Our Ref: EN010147

Application by Photovolt Development Partners (PVDP) on behalf of SolarFive Ltd for an Order Granting Development Consent for the Botley West Solar Farm

Advice following issue of decision to accept the application for examination

\* Proposed Landscape areas are indicative  
 \*\* Areas of grassland beneath /not beneath solar arrays are managed through conservation grazing, and to deliver BNG

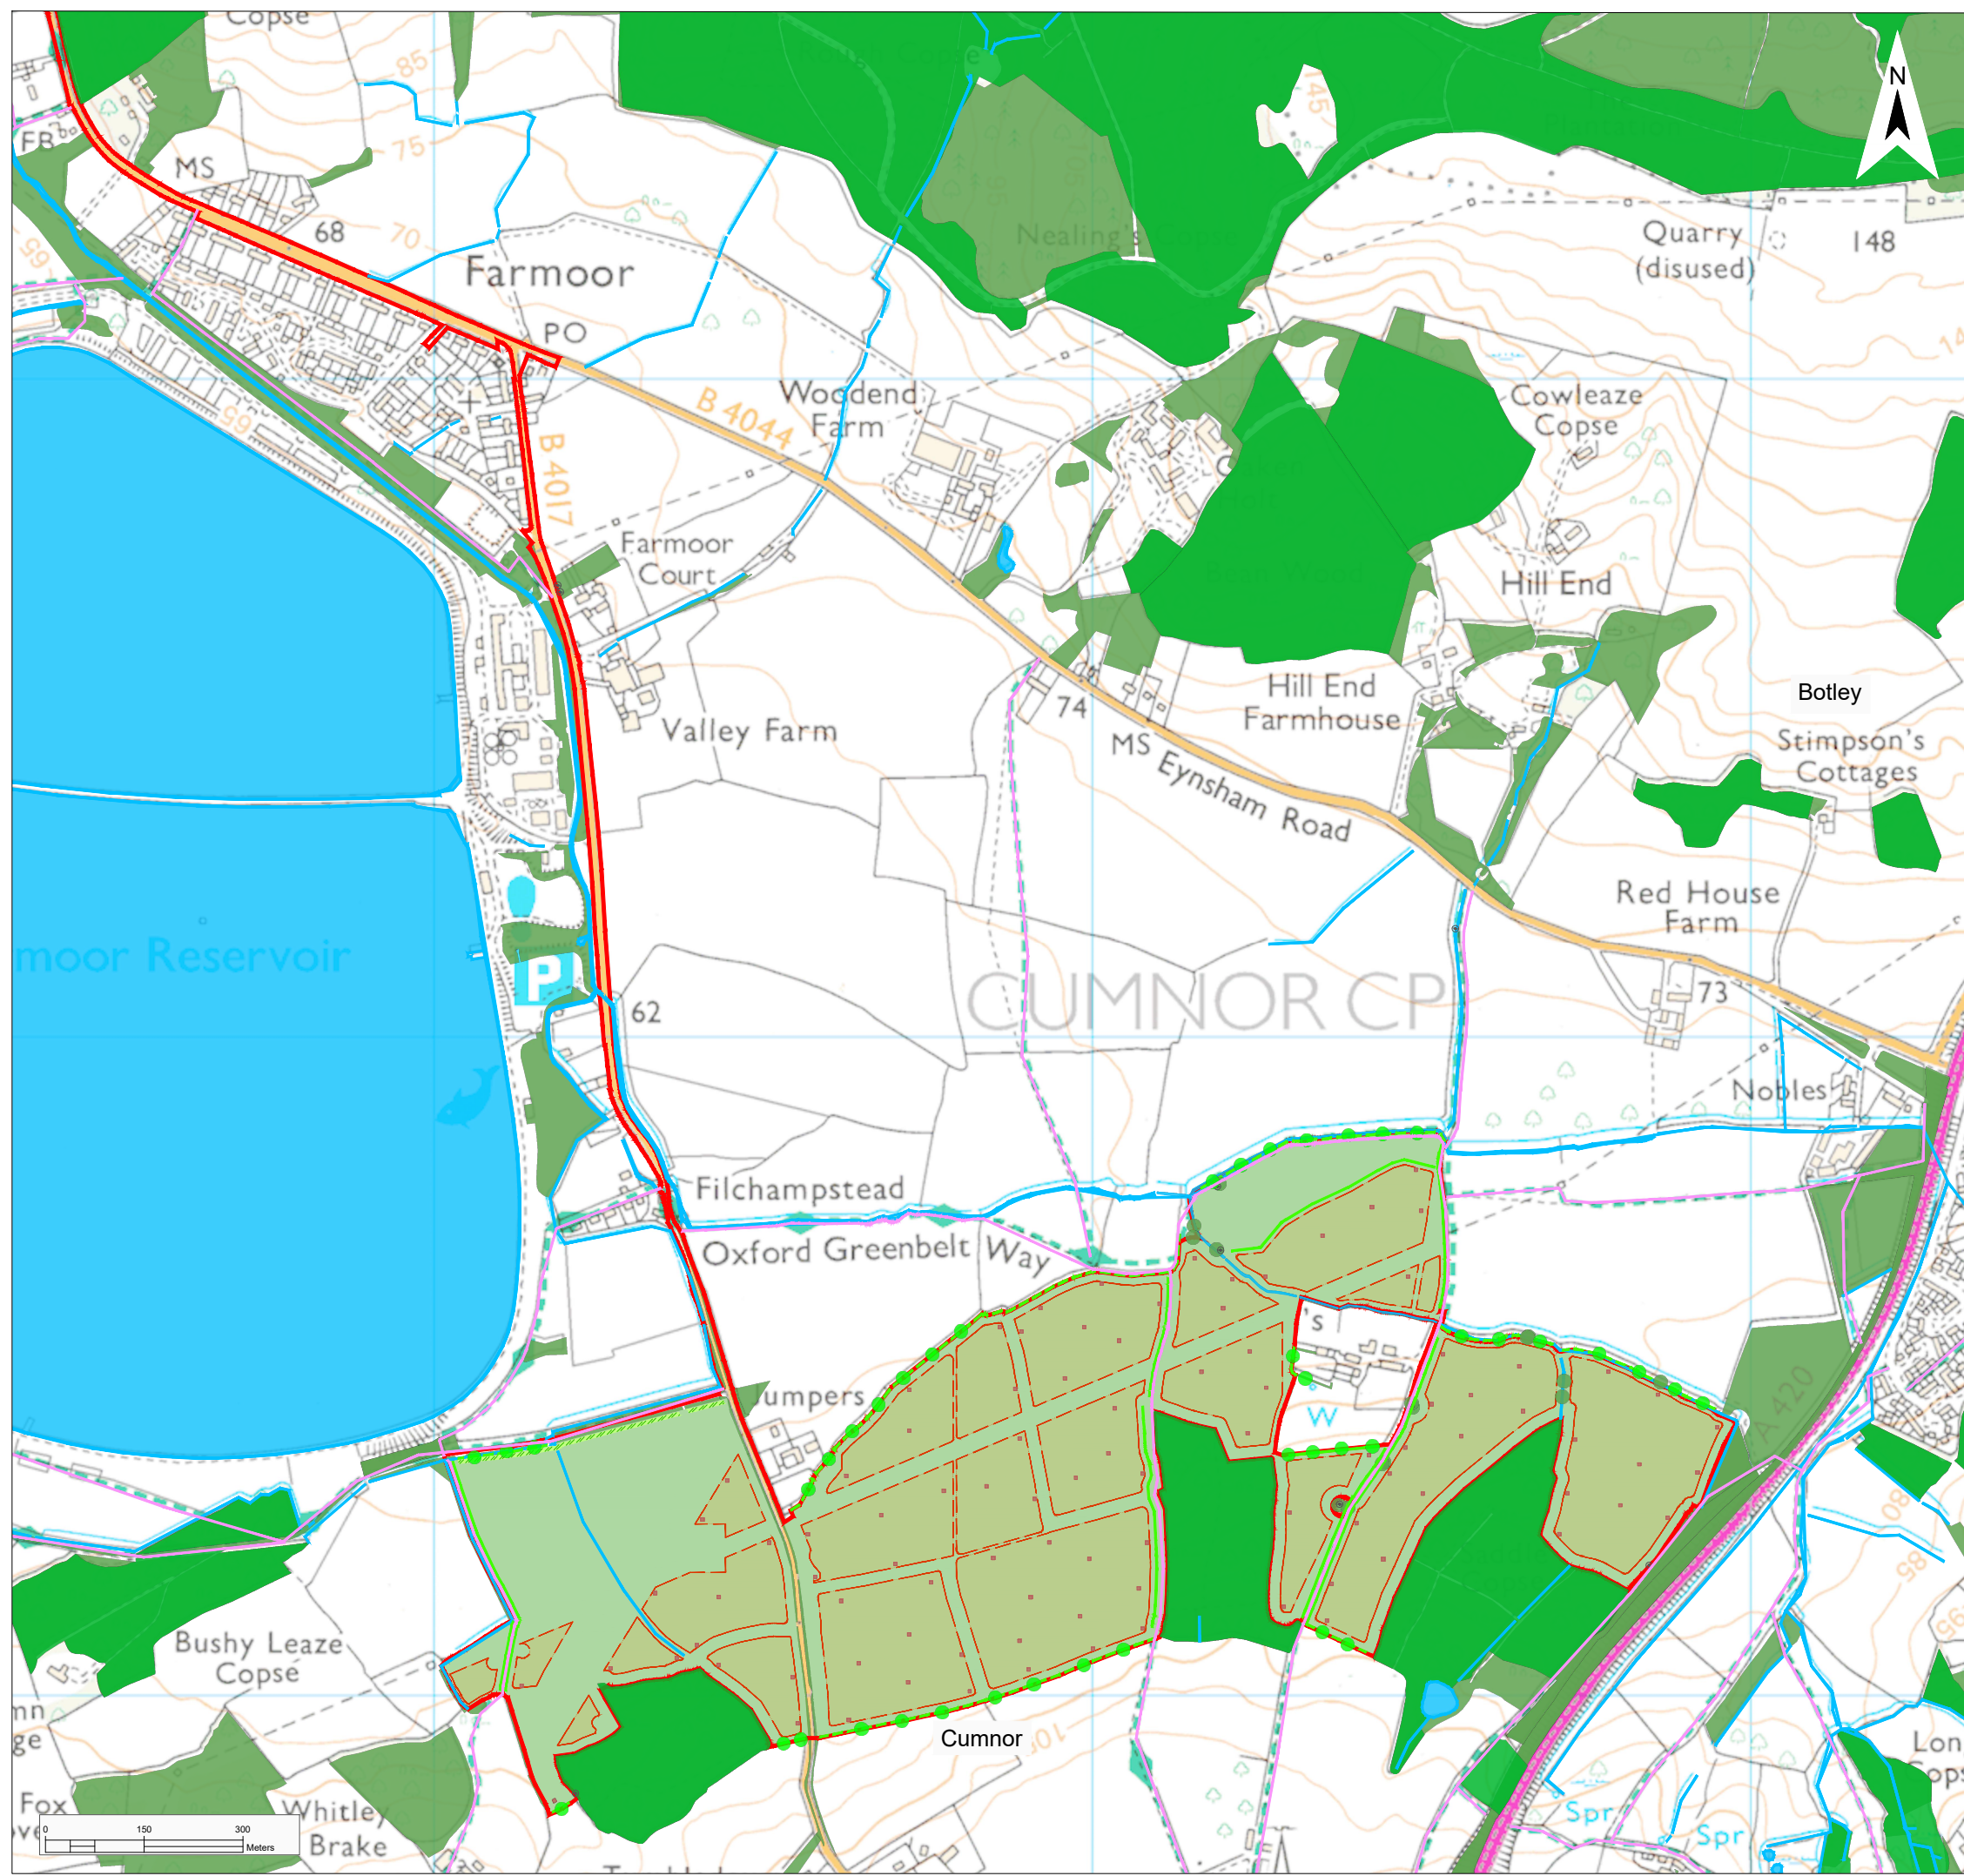
Operational Development Areas Plans (Doc 7.3.2), Landscape, Ecology & Amenities Layer Plan (Doc 7.3.3) and Temporary Facilities Plans (Doc 7.3.4)

The Inspectorate draws the attention of the applicant to APFP Regulation 5 (4A) in relation to these plan documents. The applicant may wish to amend these plans to ensure that the scale being used follows this regulation. For the benefit of the understanding of all parties to a future examination it may be desirable if it was more clearly presented on the plans which areas are within the Order Limits and how the sheet in question fits in the context of the wider site.
